**Re: Mercado El Milagro, Building G at 10,000 Central Ave SW
Erosion and Sediment Control Plan
Engineer's Stamp Date – 6/220/2023 (L09E042B)**

Based upon the information provided in your submittal received 6/23/2023, the above referenced ESC Plan cannot be approved until the following comments have been addressed.

GRADING AND  
DRAINAGE PLAN

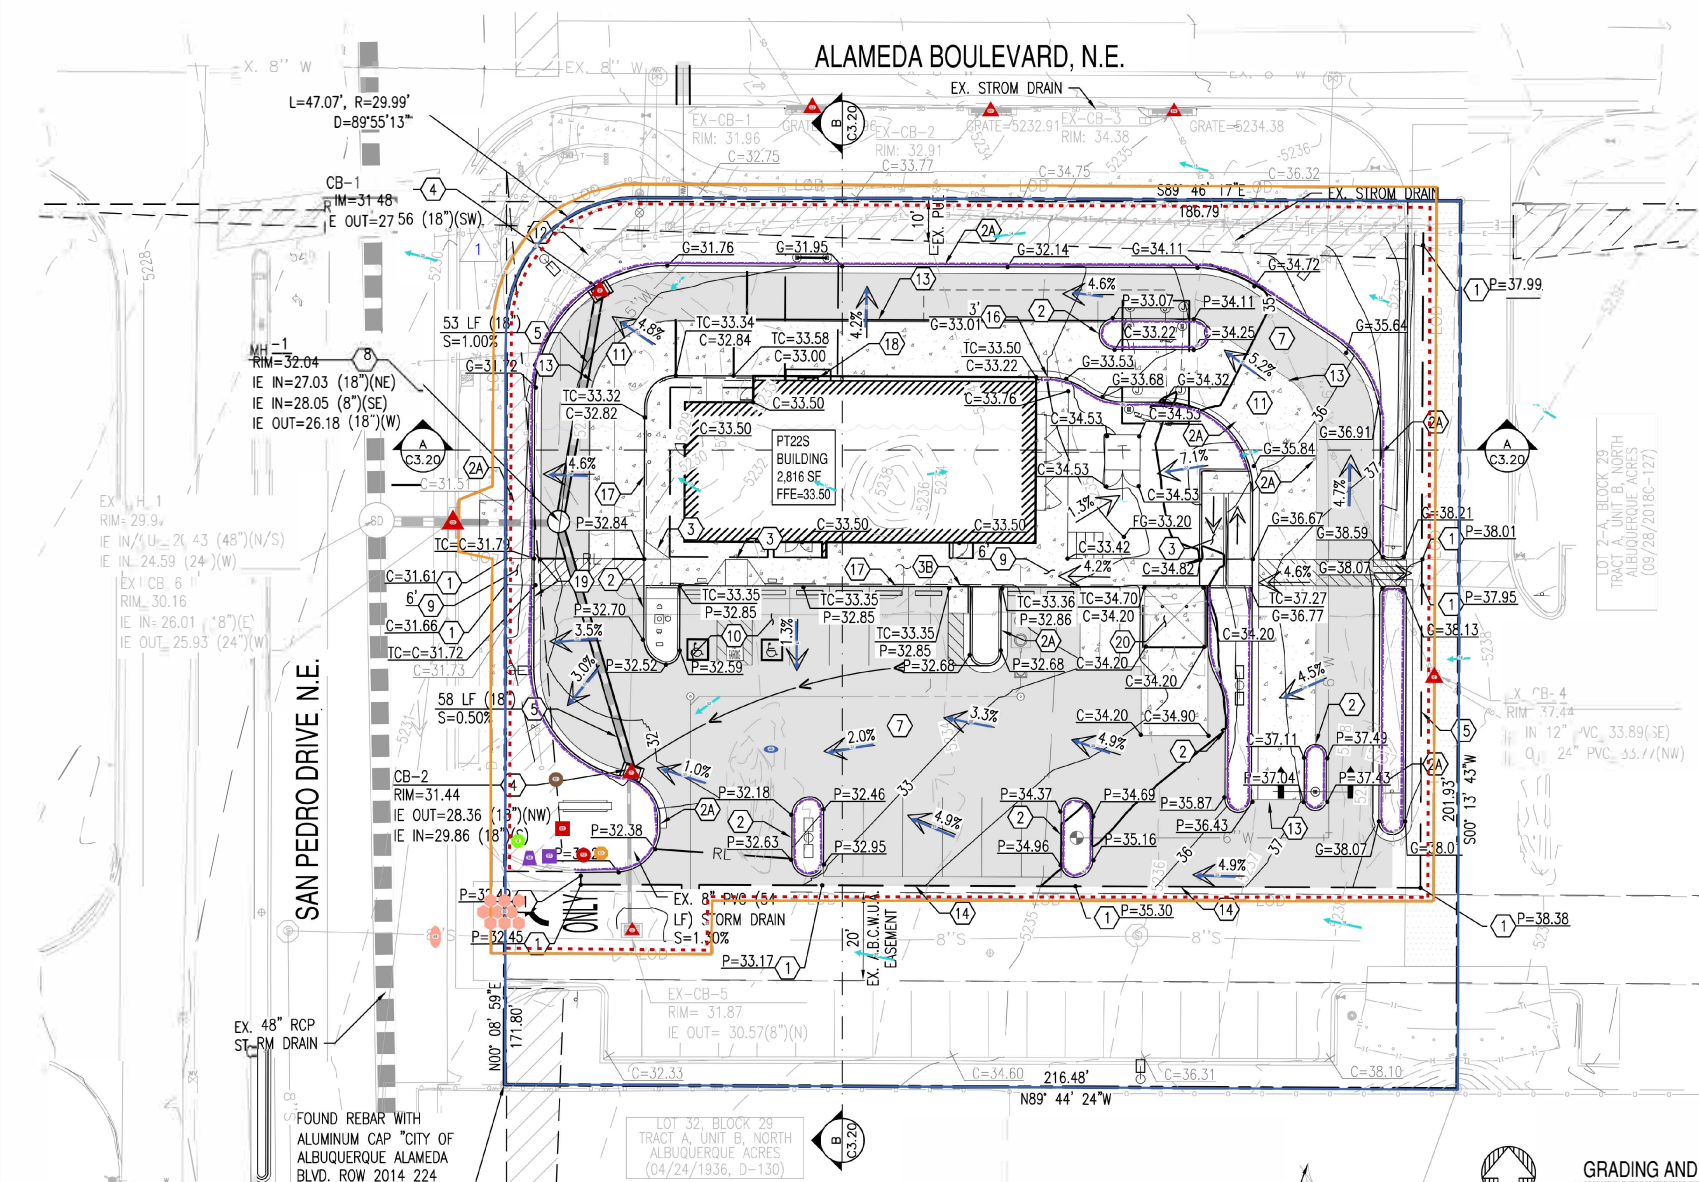
2. The existing and proposed grades must be shown on the ESC Plan, and they must agree with the Grading Plan approved by Hydrology (CGP7.2.4.b.ii). There may be more comments after the G&D Plan is approved.

3. Identify locations of concentrated flow paths that enter and exit the disturbed areas. Identify locations where sheet flow enters and exits the disturbed area. Show on-site drainage patterns of stormwater before and after major grading activities. (CGP 7.2.4.f)
